BROOKE PARISH COUNCIL

Deadline 1 Written Representation

East Pye Solar Development Consent Order

Site 9 (Brooke), associated cable corridors, construction traffic and Abnormal Indivisible Load routes

Figure 11.6: Likely and Suitable Routes to the Scheme
 Sites 7, 8 and 9
 Revision A

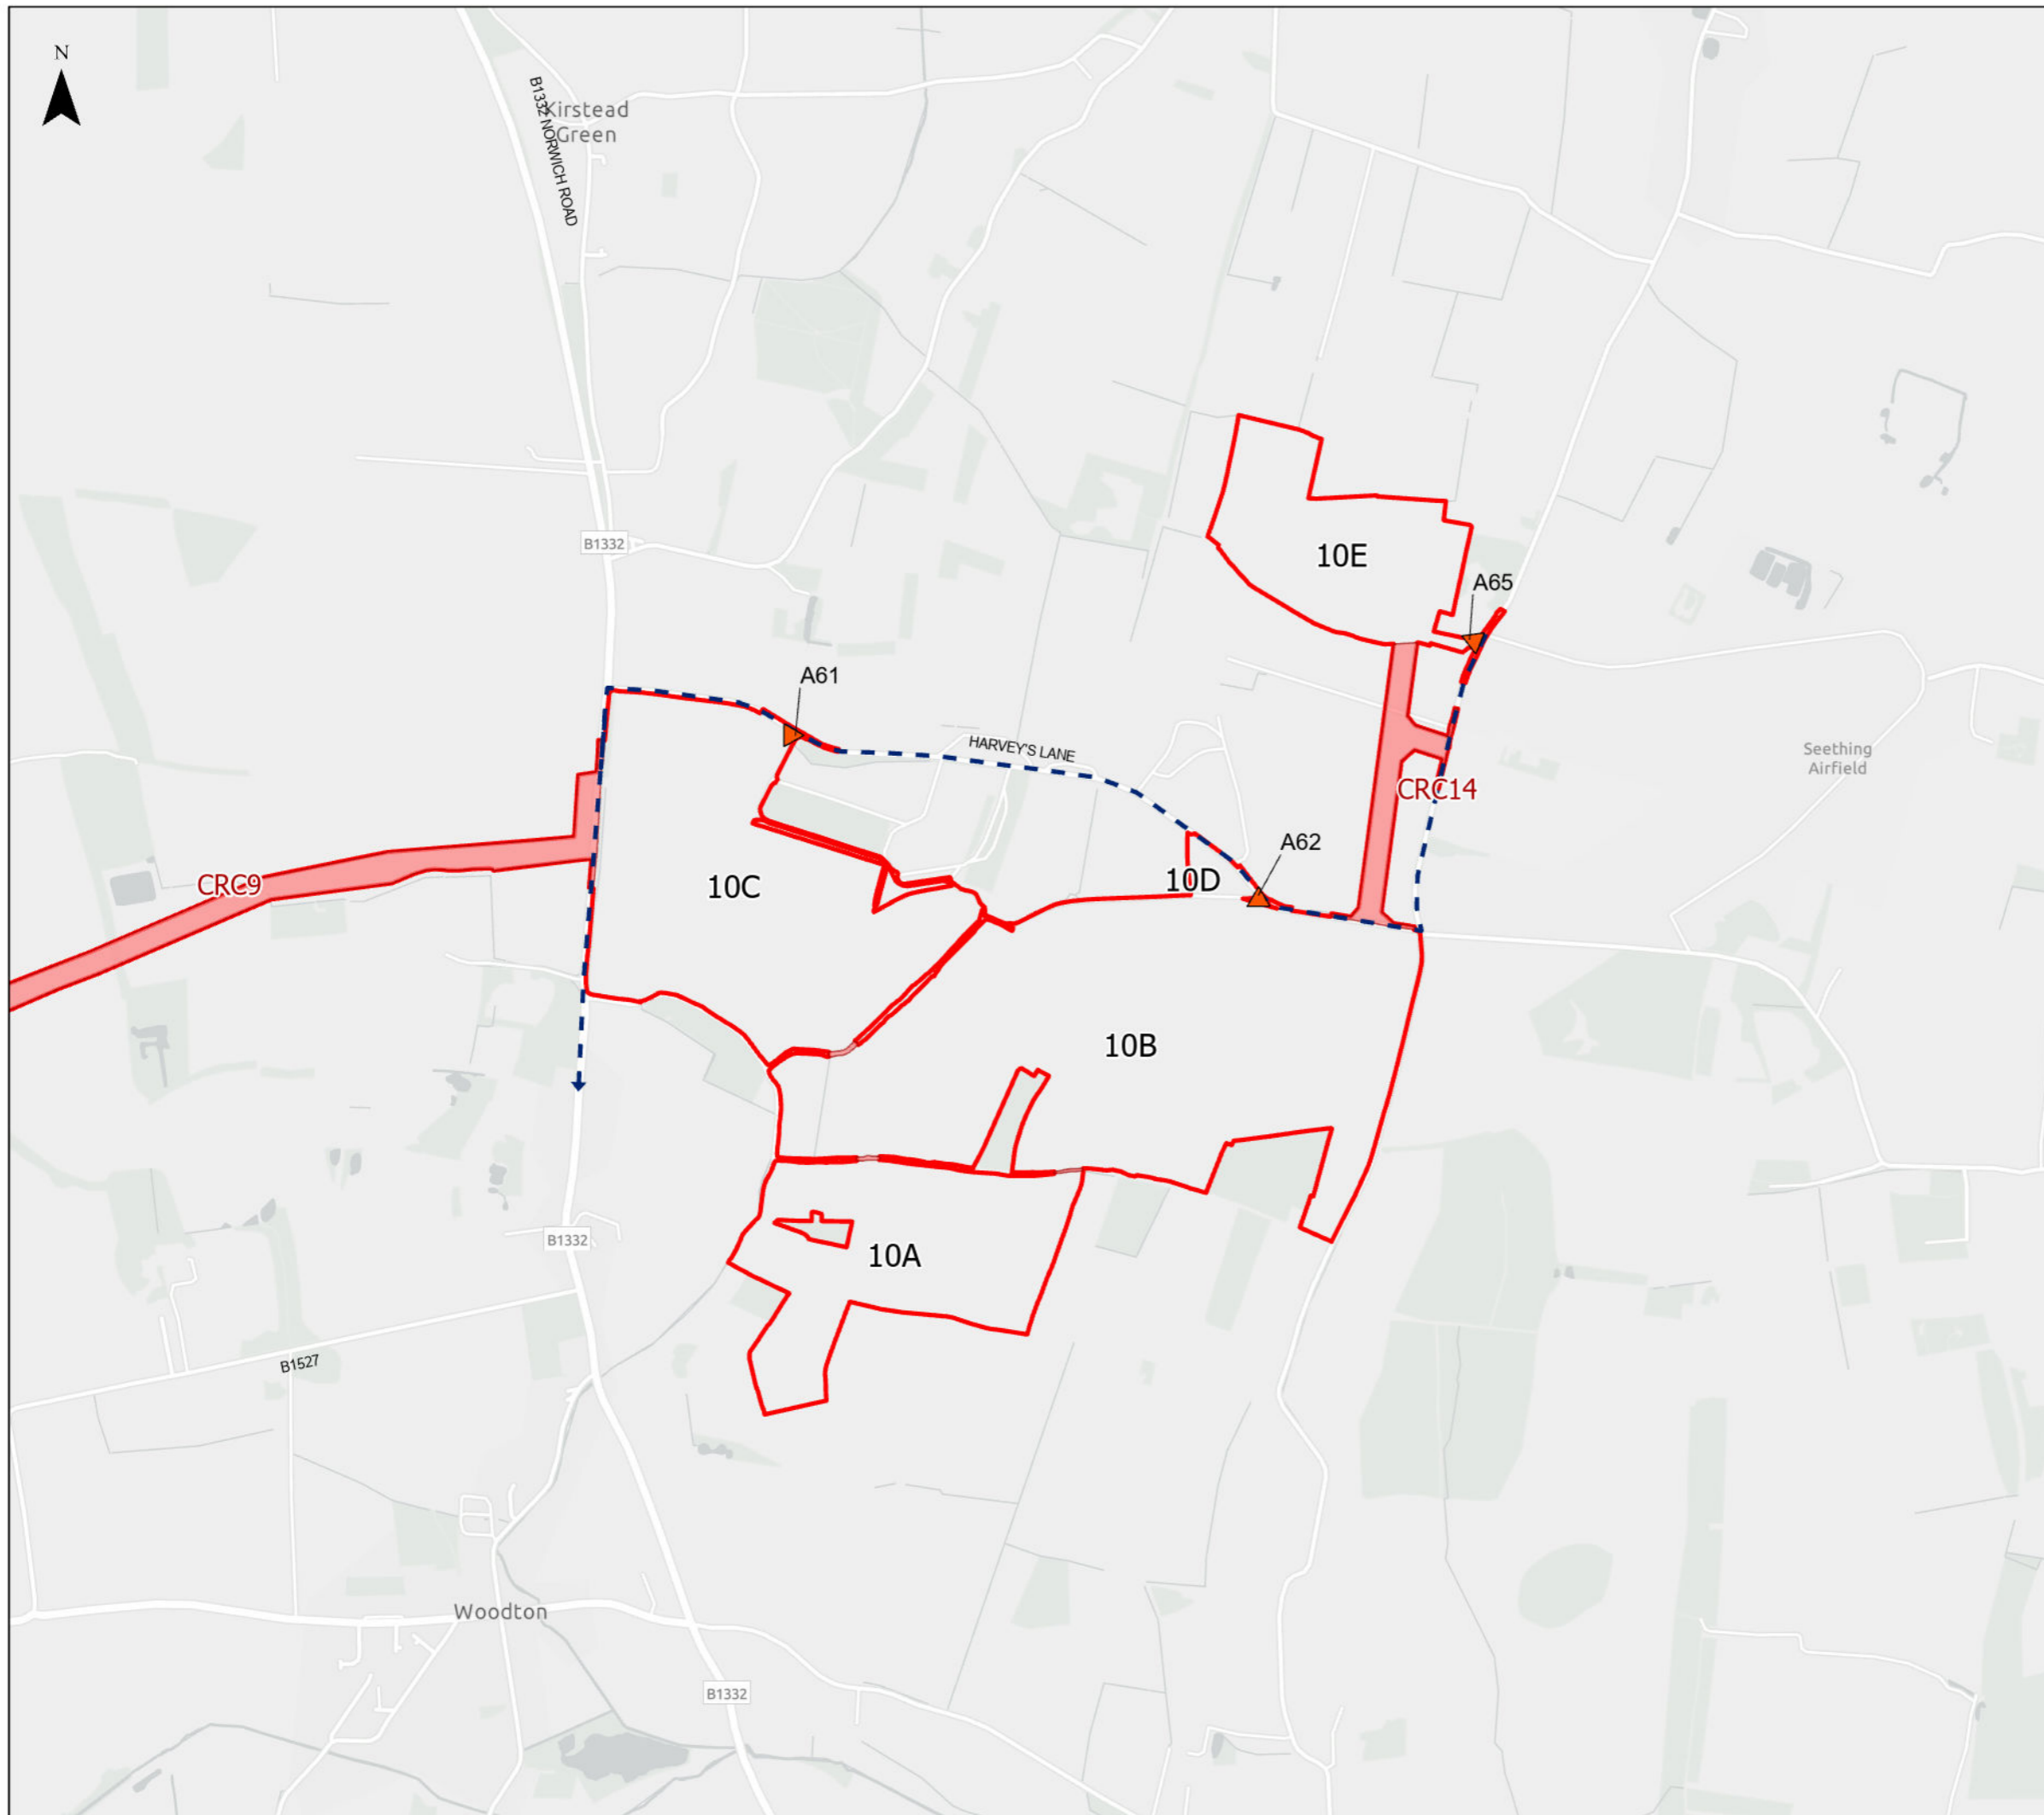
The Council considers construction transport to be a central part of the Site 9 impact. The source material describes AIL and HGV routes around the parcel using the B1332, High Green/Honeypot Lane, Littlebeck Lane/Mill Lane and Woodton Road. It also states that the Sites 7–10 transport strategy had not been accepted by Norfolk County Council in the evidence reviewed and that materially different arrangements were required. The final strategy therefore needs to be fixed and examined.

High Green passes Brooke Primary School and the Farm Shop complex, includes parked vehicles, narrows beyond Astley Cooper Place and is described as lacking footways and passing places in relevant sections. It is used by schoolchildren, pedestrians, cyclists, horse riders and horse-drawn vehicles. The source material estimates up to 136 HGV movements per day, plus an unspecified number of AIL movements. This estimate should be verified against the final construction programme and routing assumptions.

A specific assessment is requested for school travel, cycle training, school coaches, emergency access and the school's use of Wishing Wood, including periods of peak construction activity.

These lanes are described as single-track, without passing places, with ditches, listed buildings, roadside habitat and use by walkers, cyclists and equestrians. Proposed passing places, visibility splays, widening or access works must be assessed as development impacts where they require hedgerow or tree removal, verge excavation, drainage change, habitat loss or alteration of historic character.

- Definitive HGV and AIL routes, movement numbers, timing and vehicle specifications.
- Road-by-road swept-path, safety, capacity and accessibility assessment.
- Controls for school times, public transport, agricultural traffic and community events.
- Emergency access arrangements and limits on temporary closures or obstruction.
- Measures for pedestrians, cyclists, equestrians and horse-drawn vehicles.
- A Construction Traffic Management Plan secured through the DCO and developed in consultation with Brooke Parish Council.
- Advance notification, complaints handling, monitoring and enforceable breach-response procedures.
